Our Case Number: ACP-323849-25

Re: The proposed development is for a mixed use development that seeks the regeneration and adaptive reuse of a strategic brownfield site, as part of the Limerick City and County Council 'World Class Waterfront revitalisation and transformation project' 'Cleeves Riverside Quarter' in the townland of Farranshone More in Limerick City.

Re: Proposed Development - Cleeves Riverside Quarter / Riverside Campus

Observation / Objection

drawing	Stonetown Terrace First & Second Floor Plan - Proposed				
drawing no.	CRQMP-BMEA-3X-ZZ-DR-AA-2021				
project	scale	1:200 @ A1	drawn	AL/LV	project no.
Cleeves Riverside Quarter Masterplan	date	Oct. 2025	checked	KH	CRQMP
client	Limerick Twenty Thirty				
	revision	P01

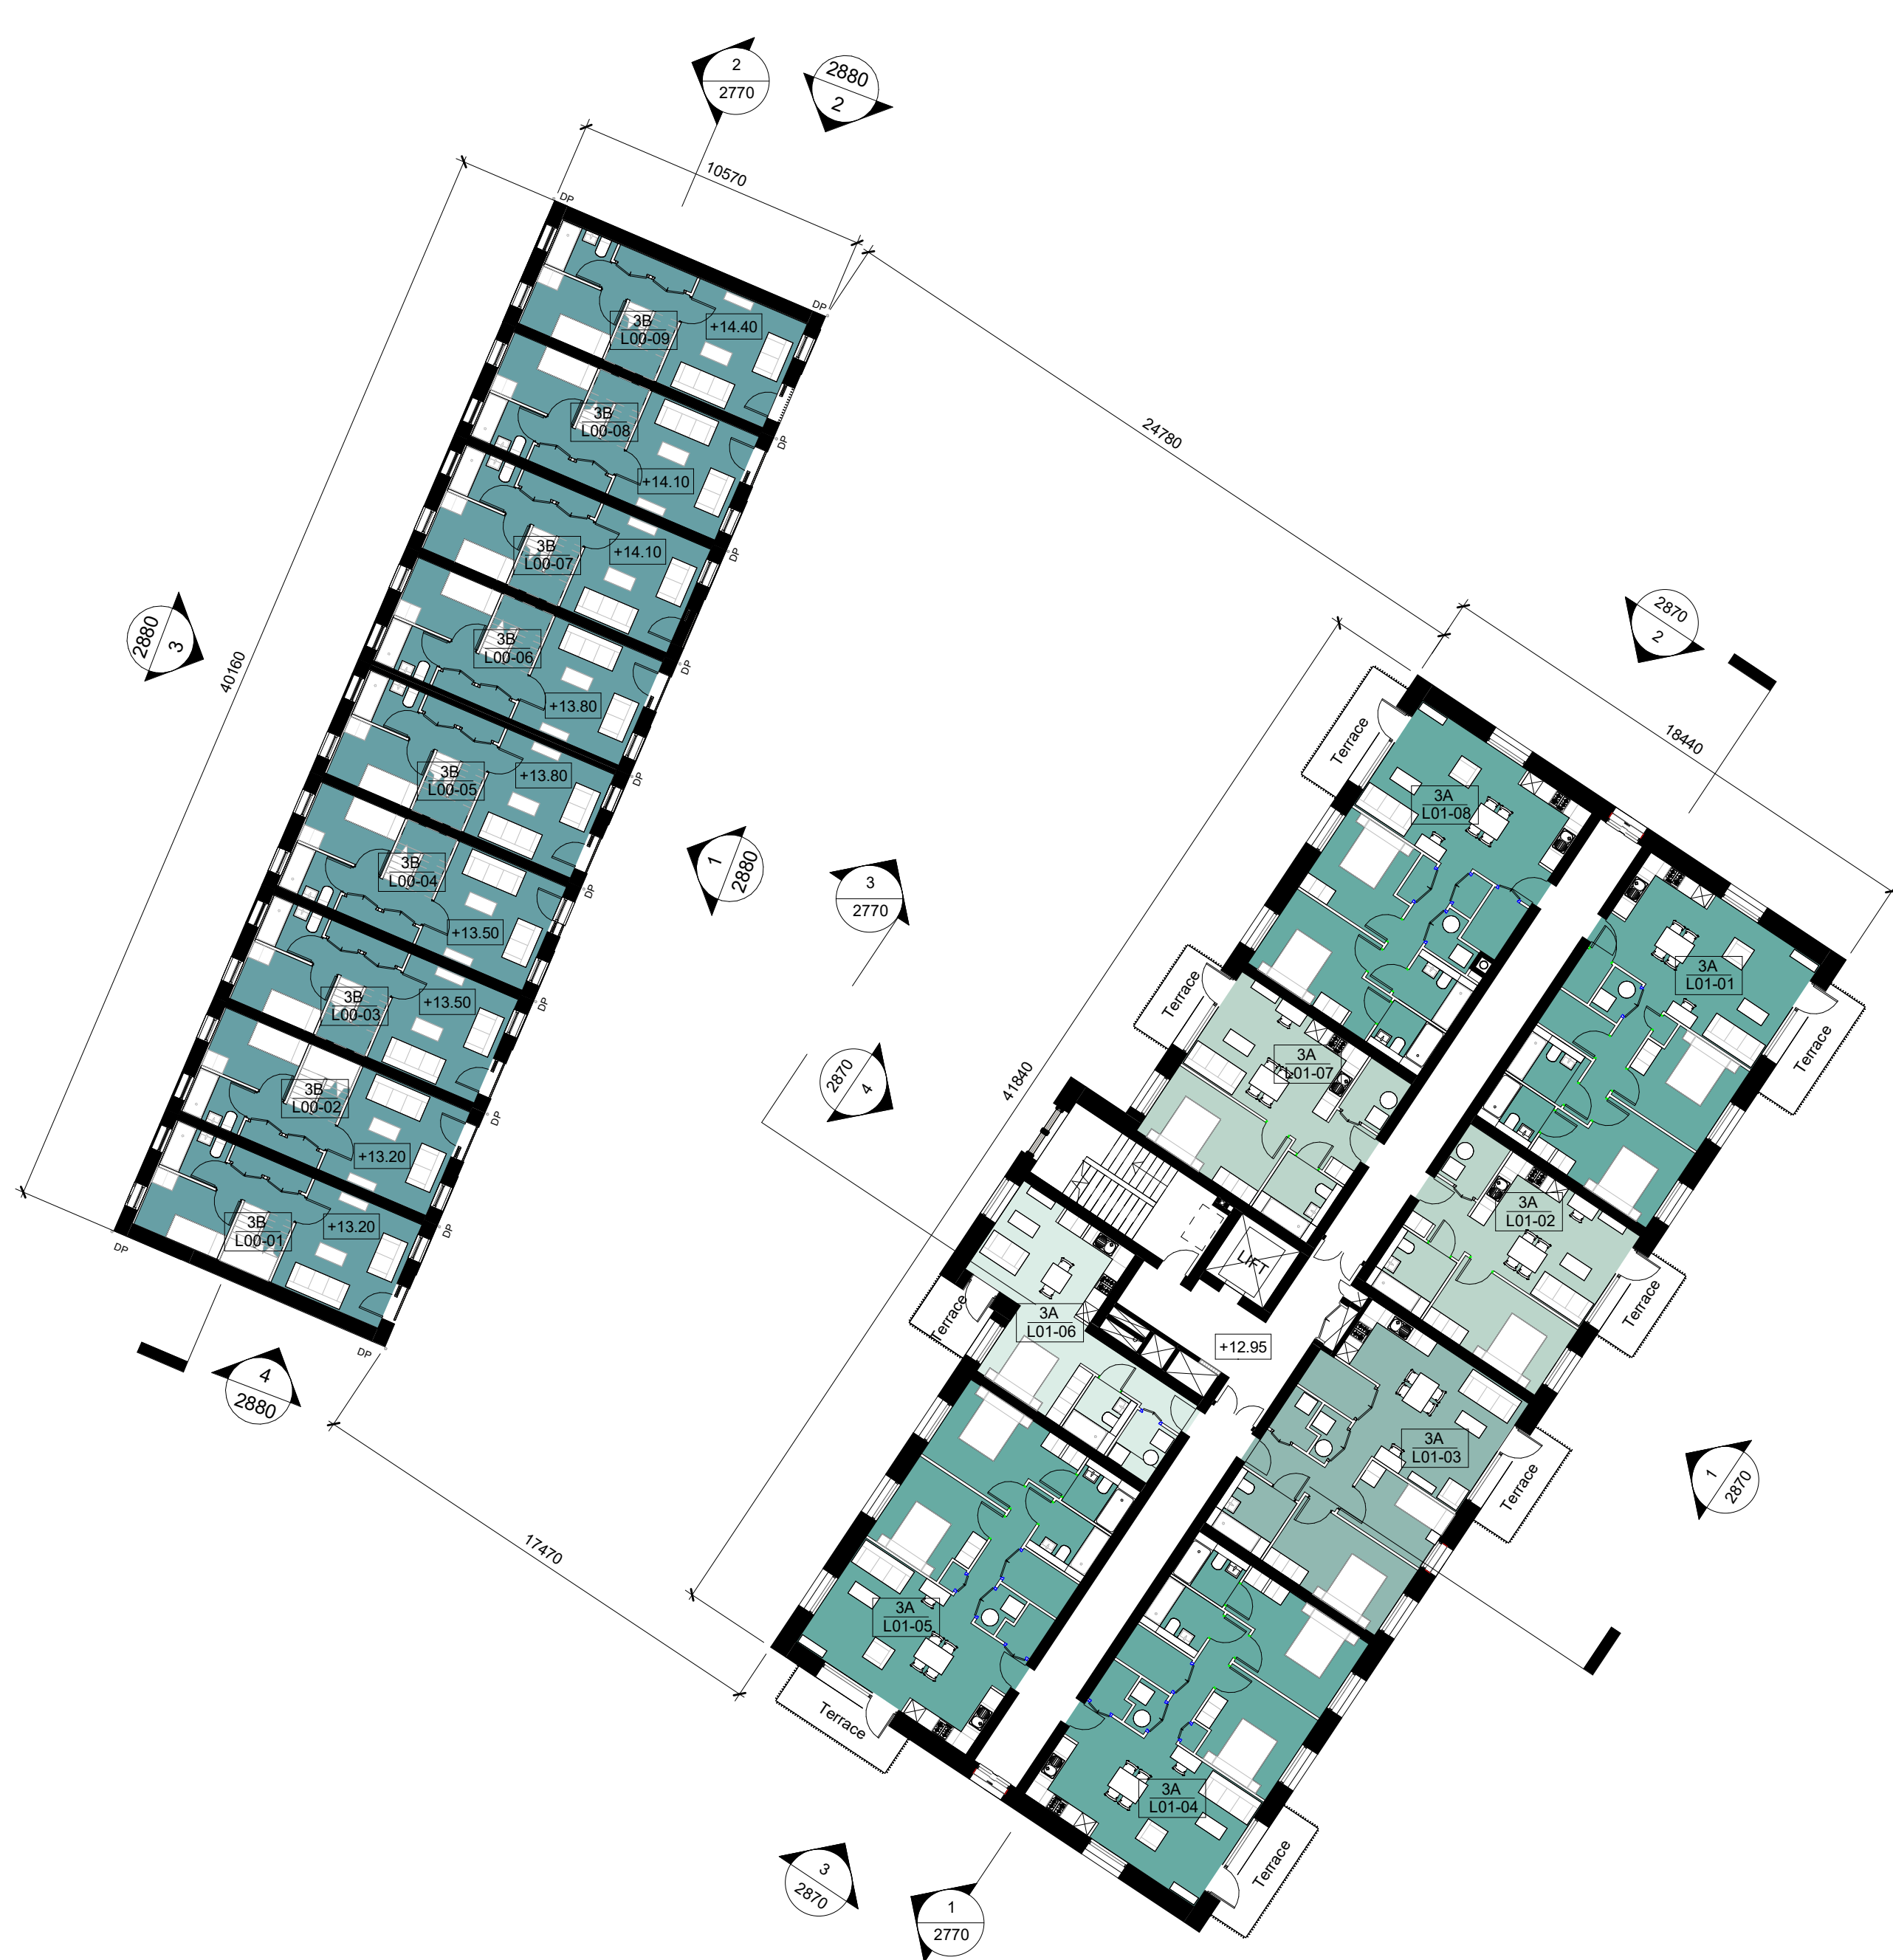
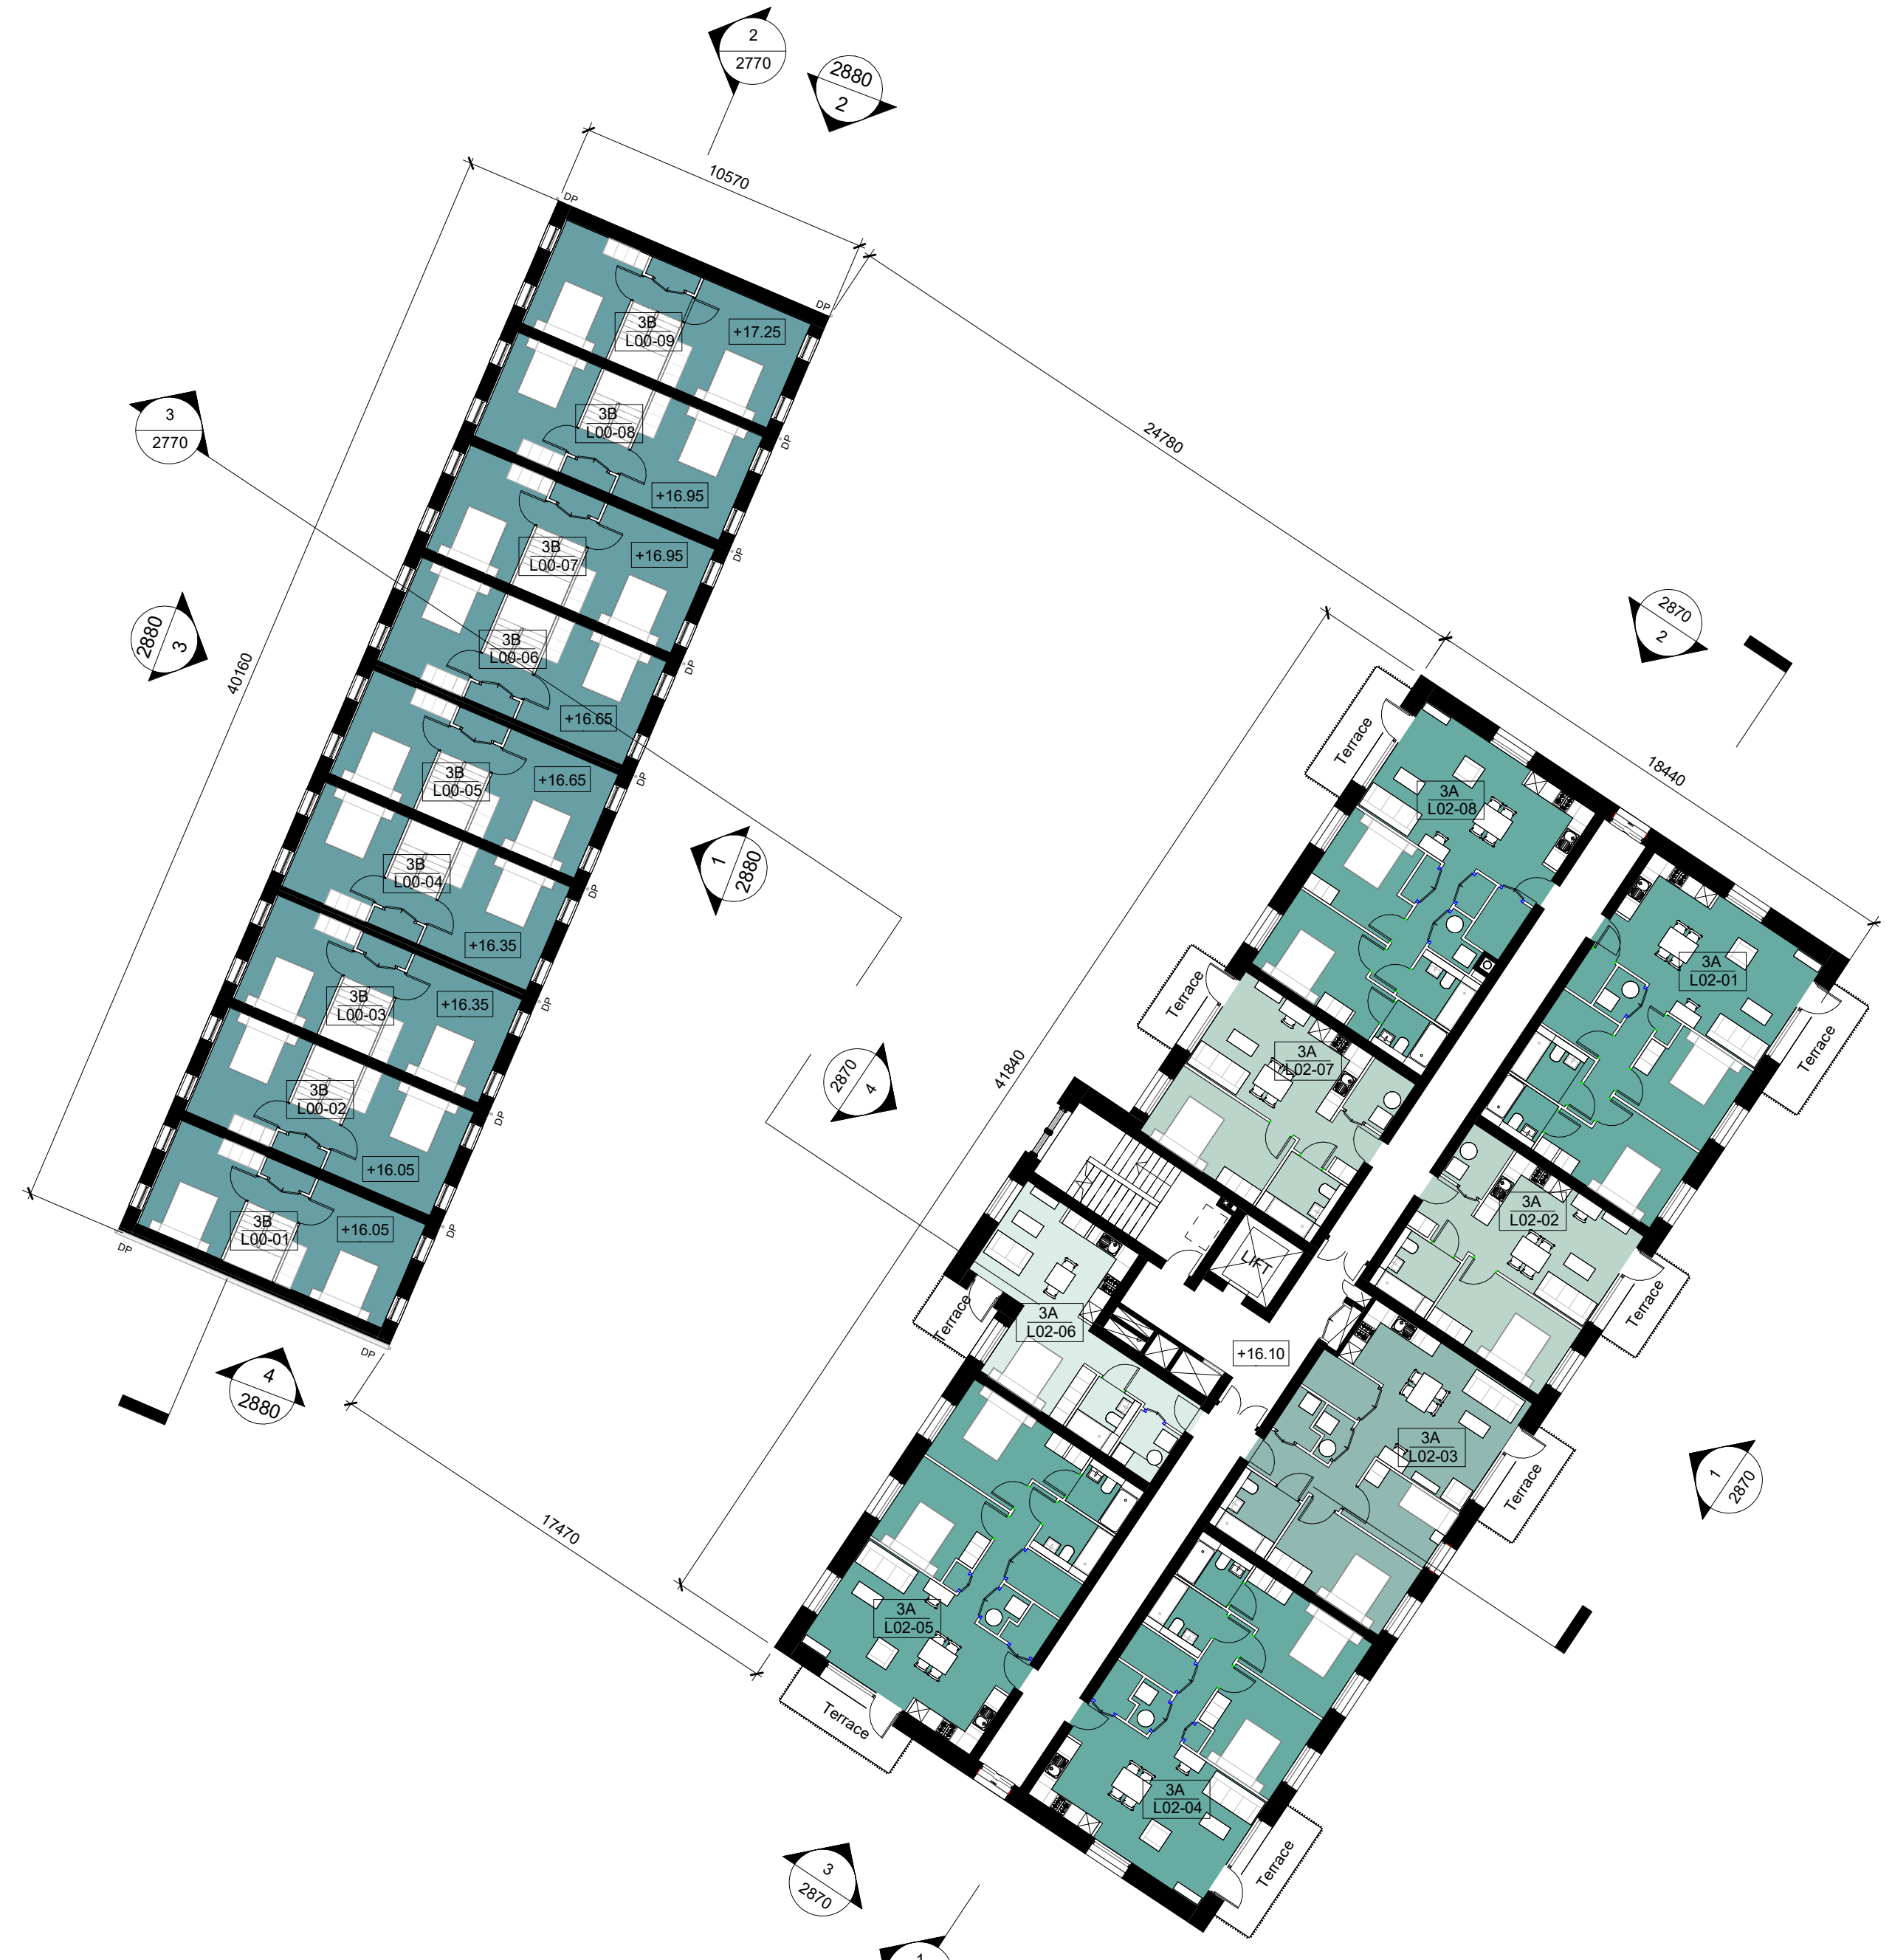
- The volume and height of the proposed buildings are totally out of character with the existing residential context. The building will be visually overwhelming due to its mass and sheer scale. The visual impact will be even greater because of the close proximity to the existing dwellings .

- The height and mass of the proposed building across the narrow street dwarf the surrounding dwellings and will also have a disastrous impact on the amount of light and sun reaching the adjacent houses. The assertion made by the applicant that 'the proposed development will have minimal impact to the sunlight received by the neighbouring properties', is blatantly untrue and arguably disingenuous.

- The height, aspect and the planned situation of windows in the building will have an extremely negative outcome on the privacy of the residents. The houses of Stone Town Terrace are all bordering and facing the road, with their gardens situated at the front. The houses and gardens will be directly in the line of vision of future inhabitants of the multi-storied building across, resulting in a total loss of privacy for the existing residents.

drawing Stonetown Terrace Ground Floor Plan - Proposed

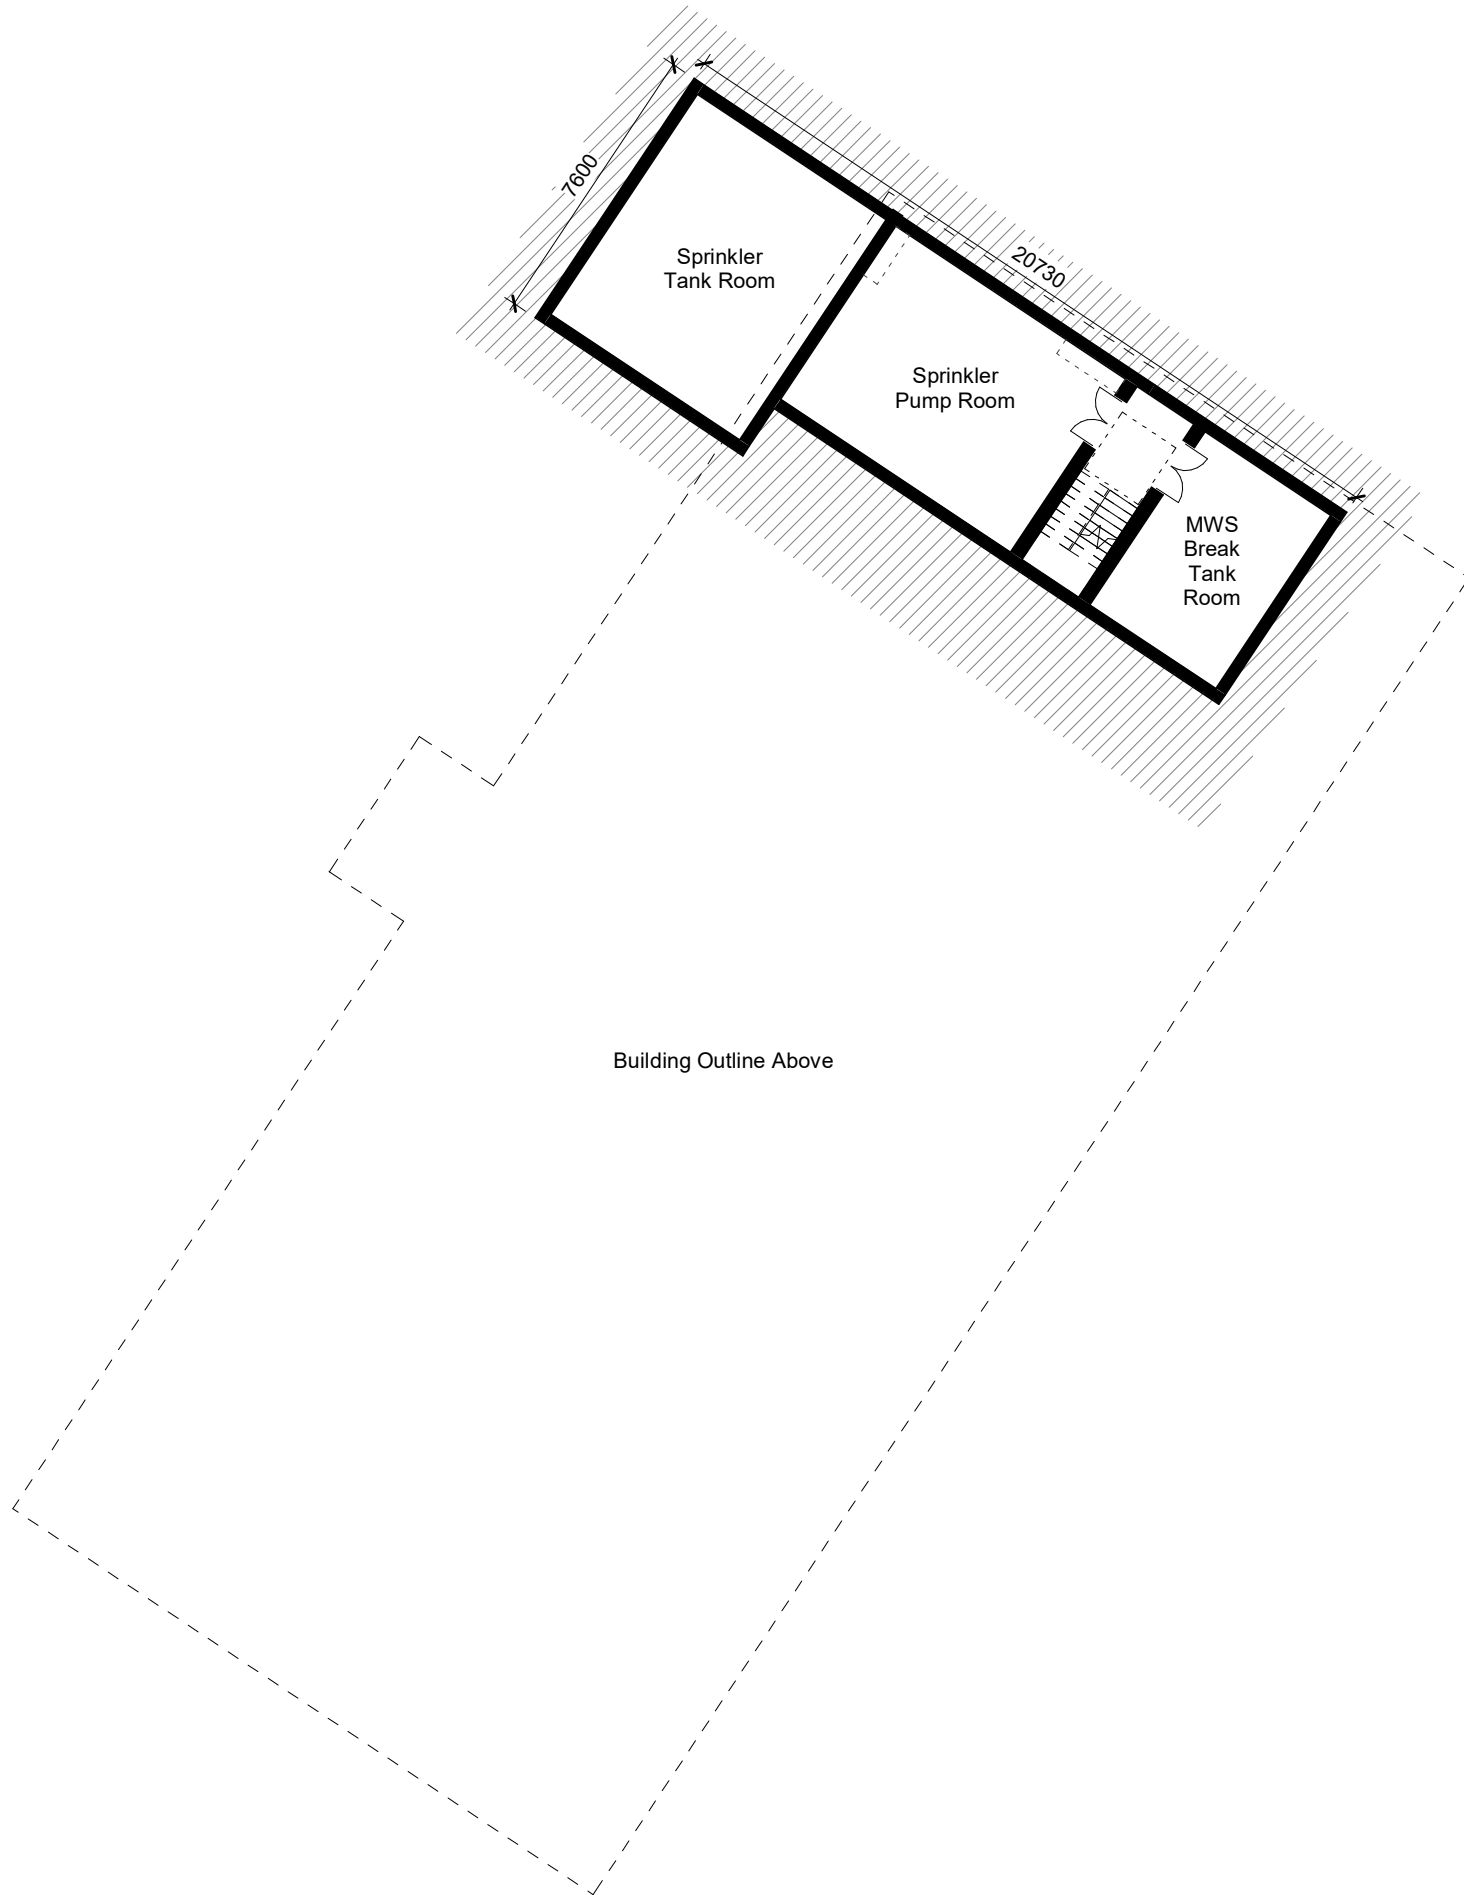
Particularly objectionable is the proposal to provide an entrance/ exit point by making a passageway in the boundary wall halfway up Stone Town Terrace and allowing access from new development, further exacerbating congestion and safety issues. It seems contrary to all good and honest planning to put forward a plan which does not account for these clear, foreseeable, and substantial problems.
